CITY OF ALBUQUERQUE

Re: Solare Charter School, Phase 1
8801 Gibson Blvd SW
Request for Certificate of Occupancy
Transportation Development Final Inspection
Engineer's/Architect's Stamp dated 6-17-19 (M09D031)
Certification dated 2-20-20

Based upon the information provided in your submittal received 2-18-20, Transportation Development cannot approve the release of Certificate of Occupancy for the above referenced project.

TITLE
Traffic Control Layout

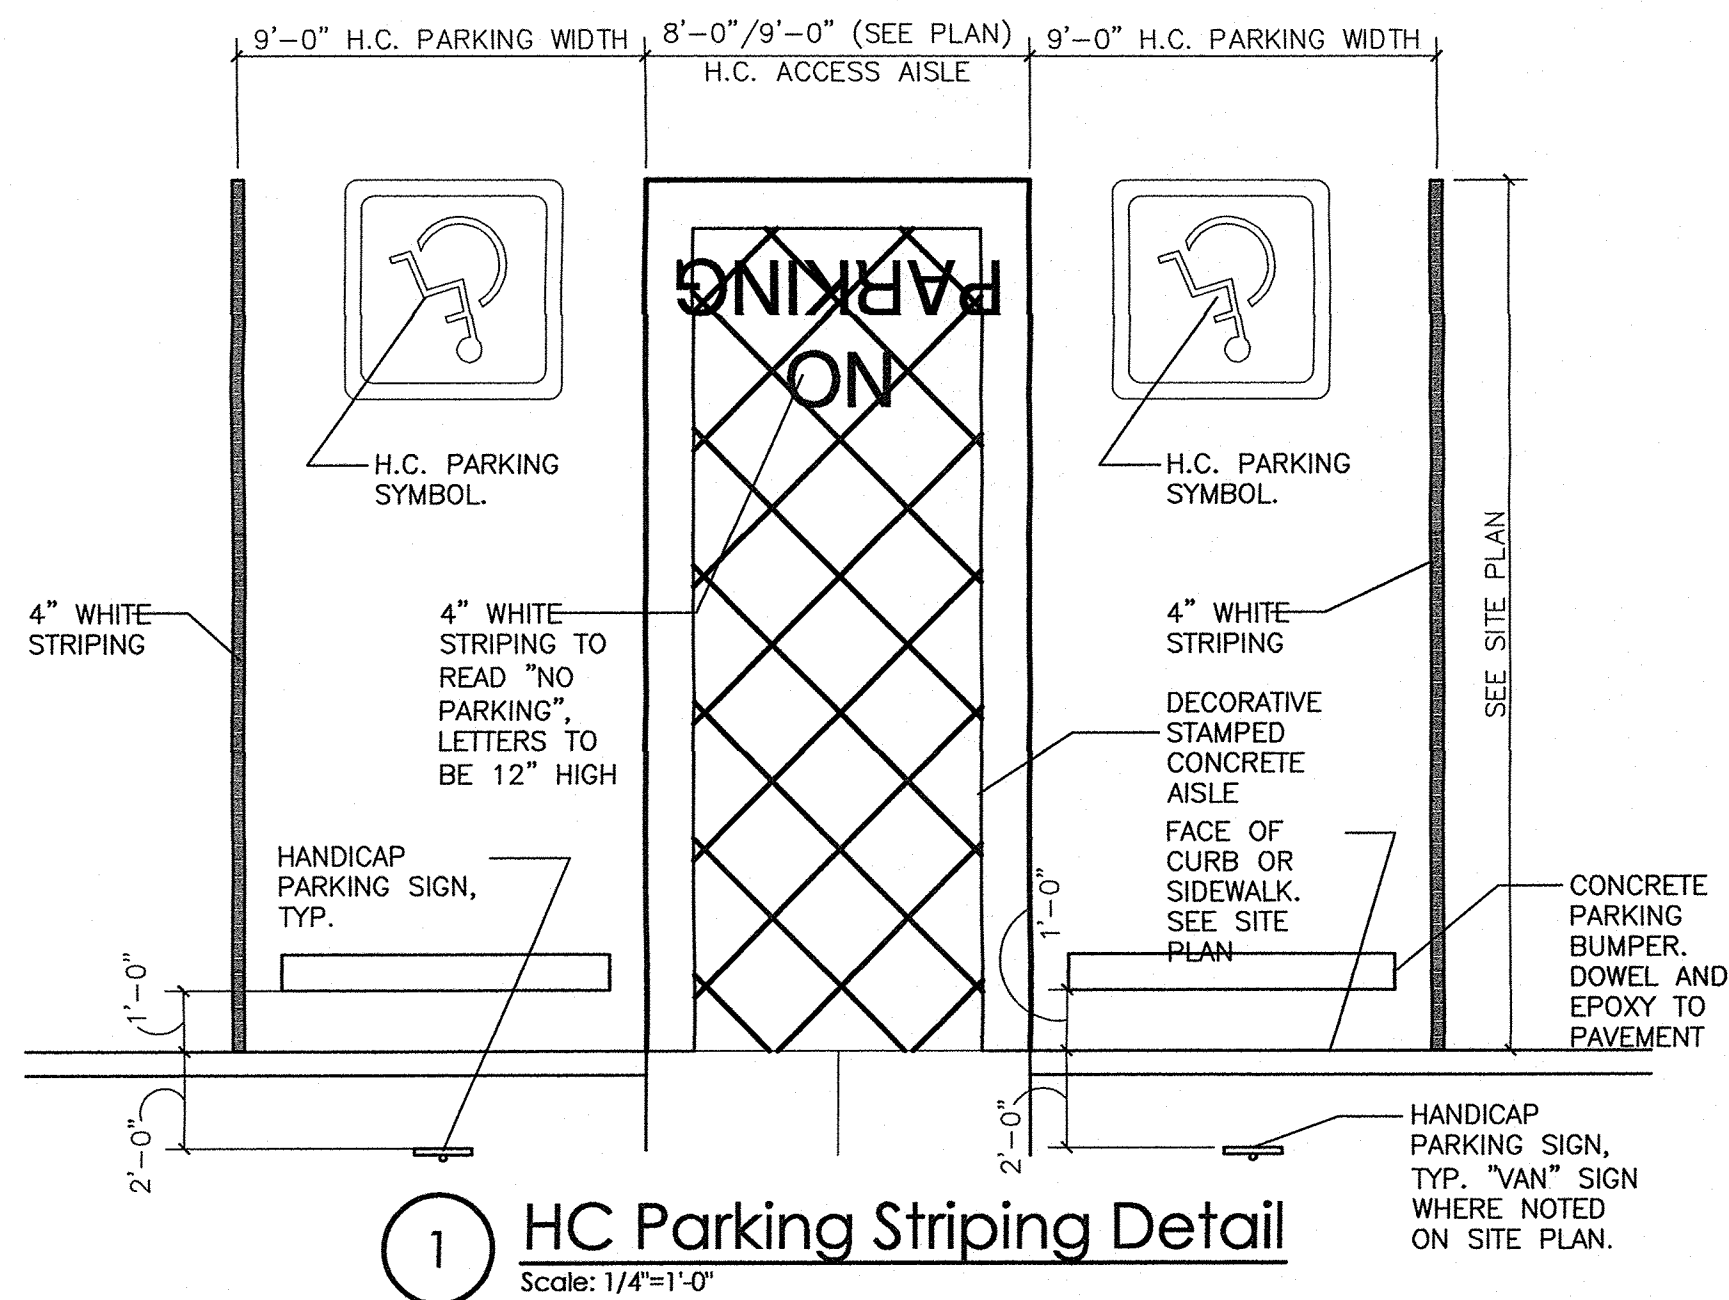
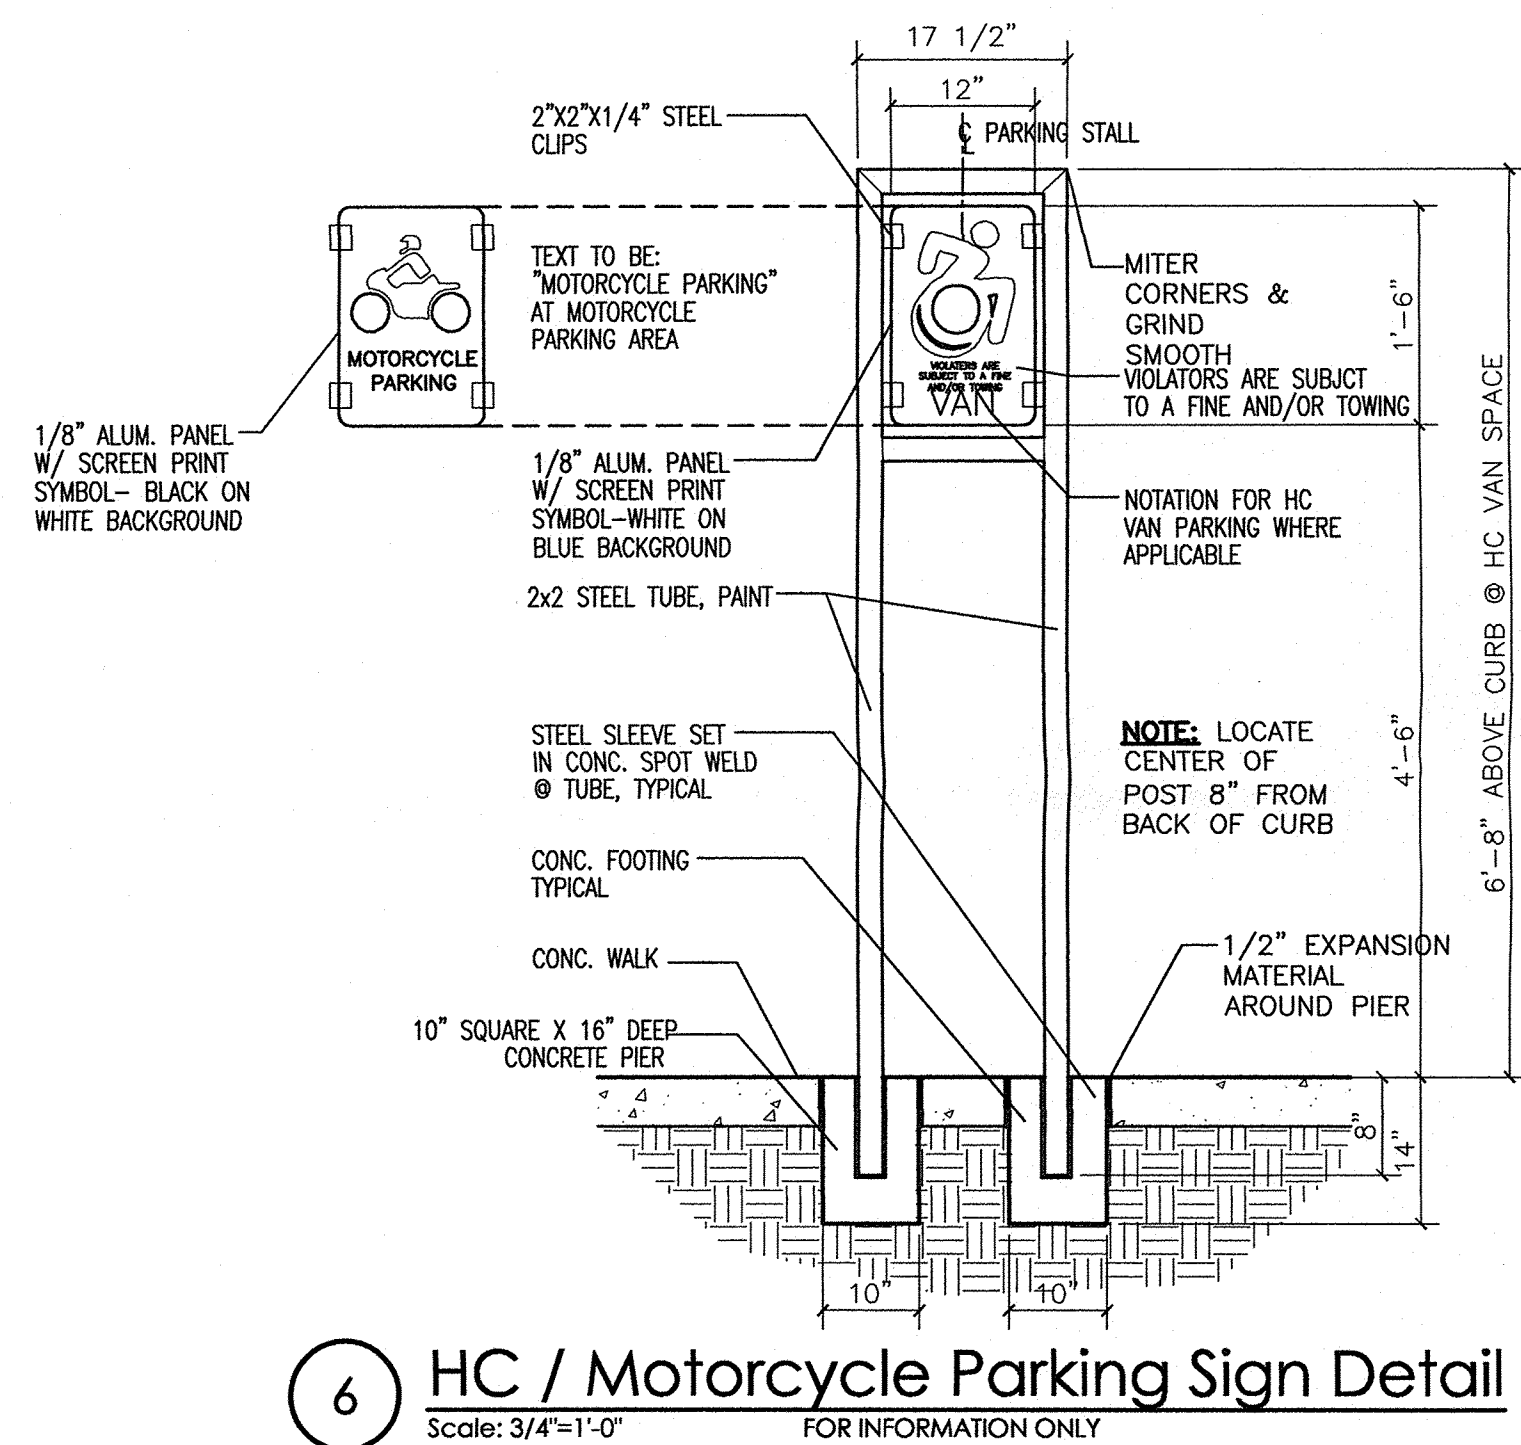
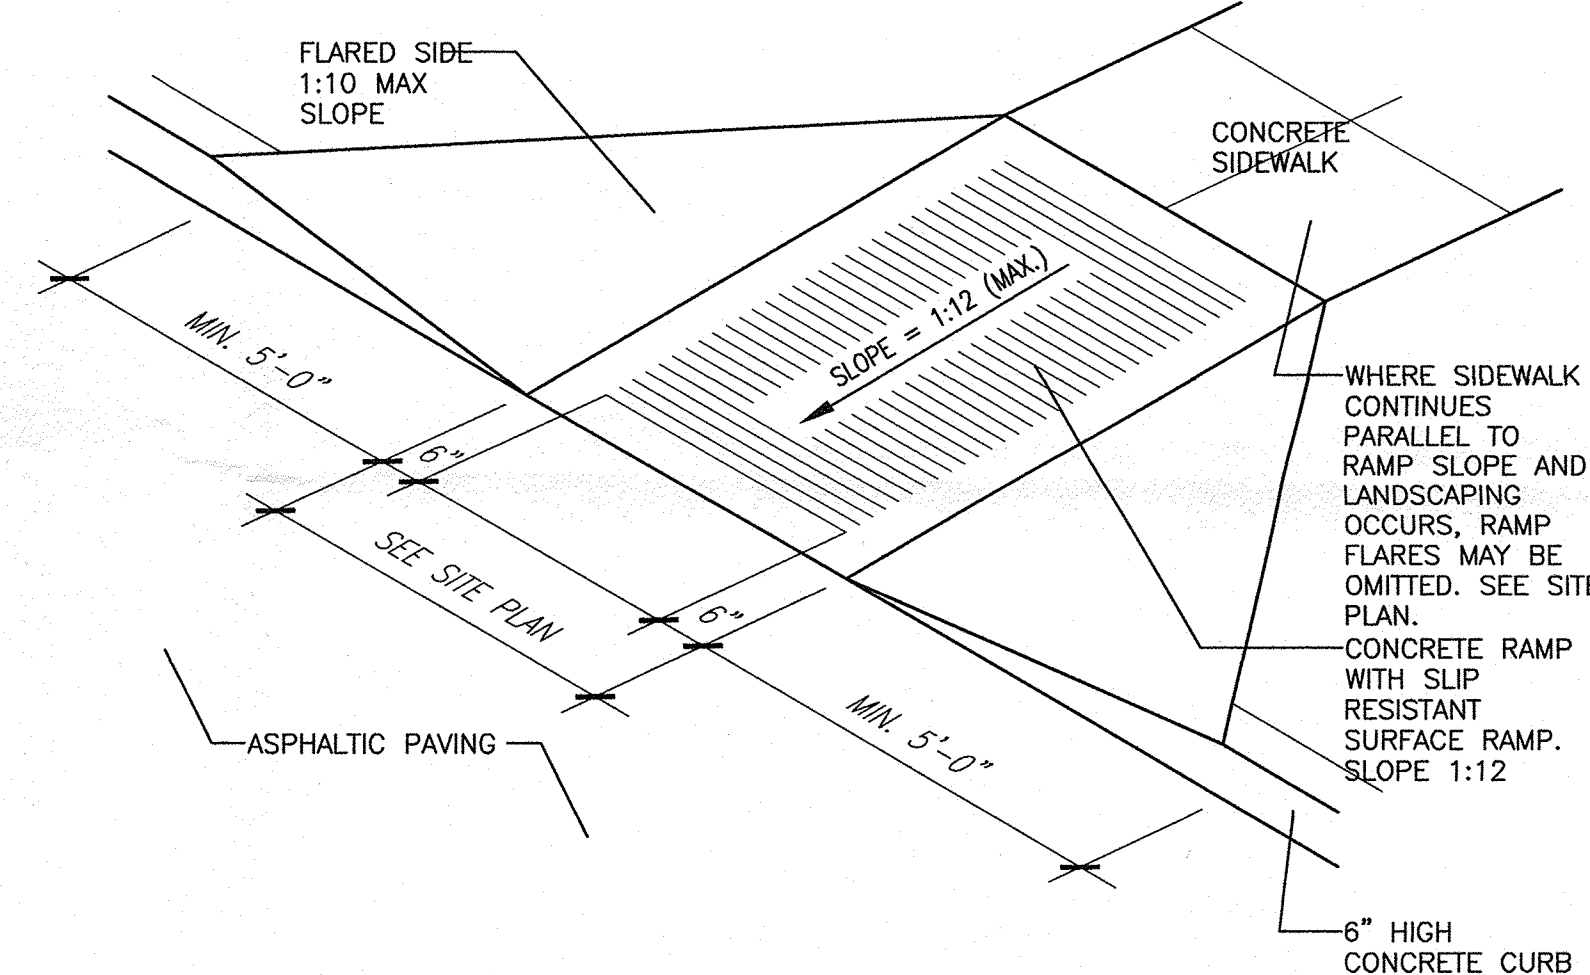
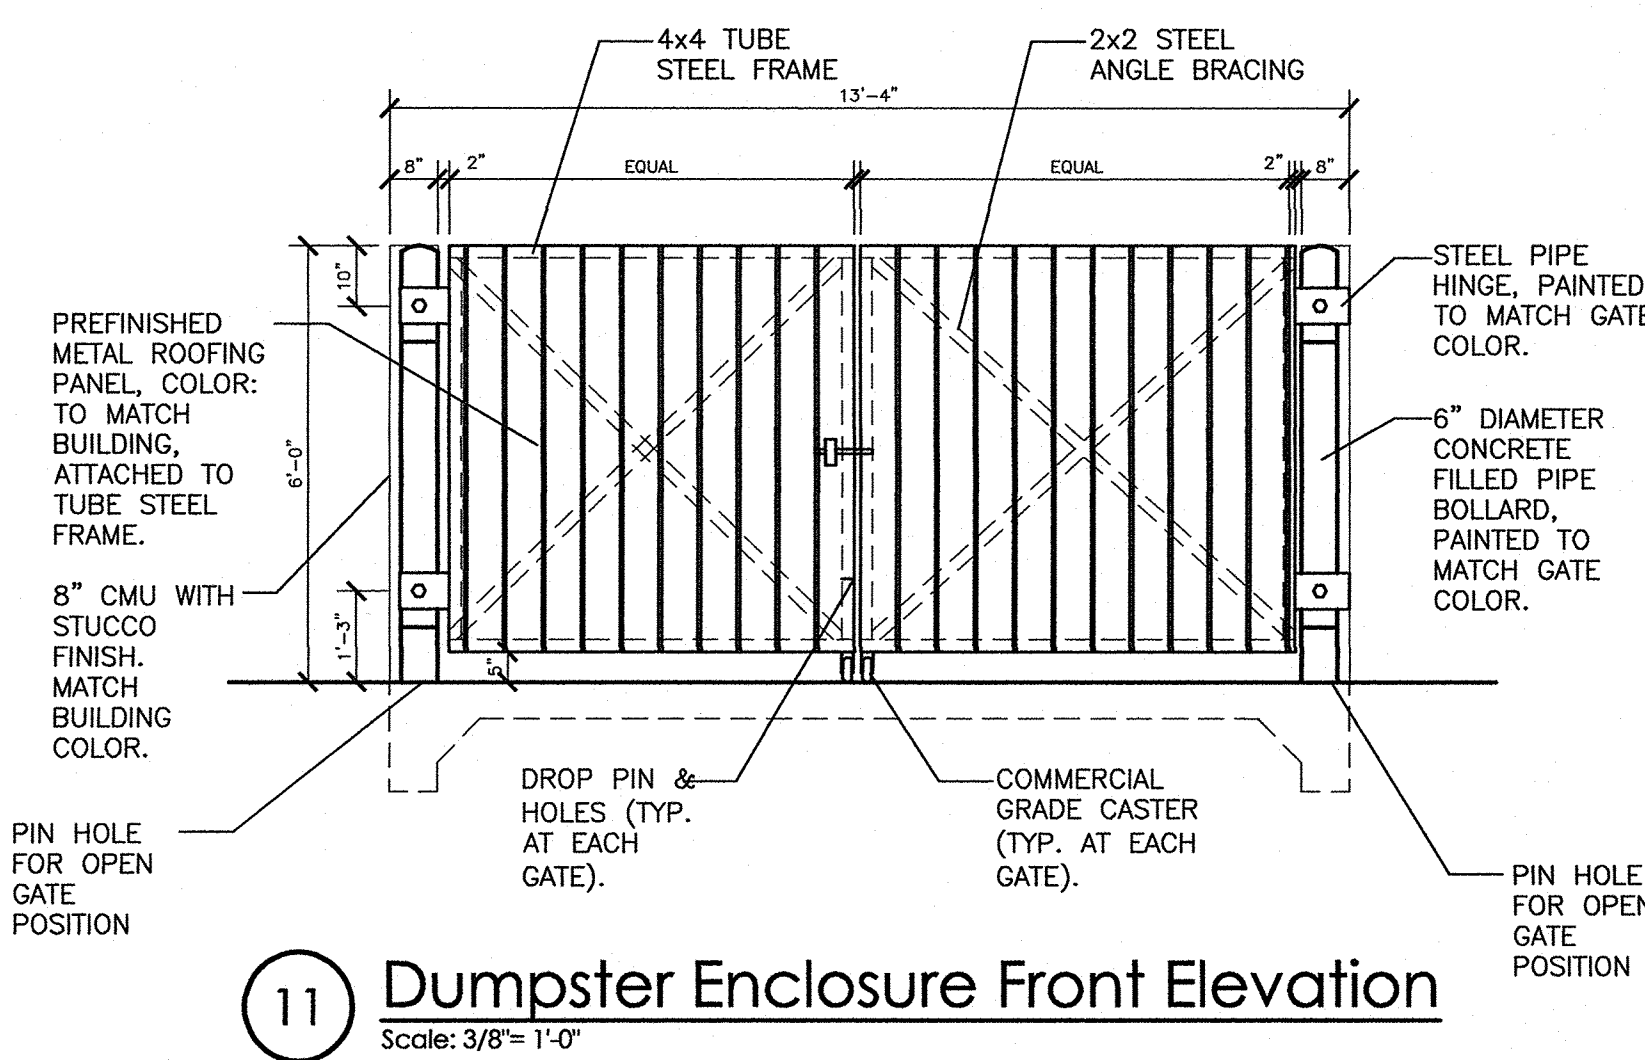
- Please complete bike trail keynote #27.
- Pending Hydrology Approval.
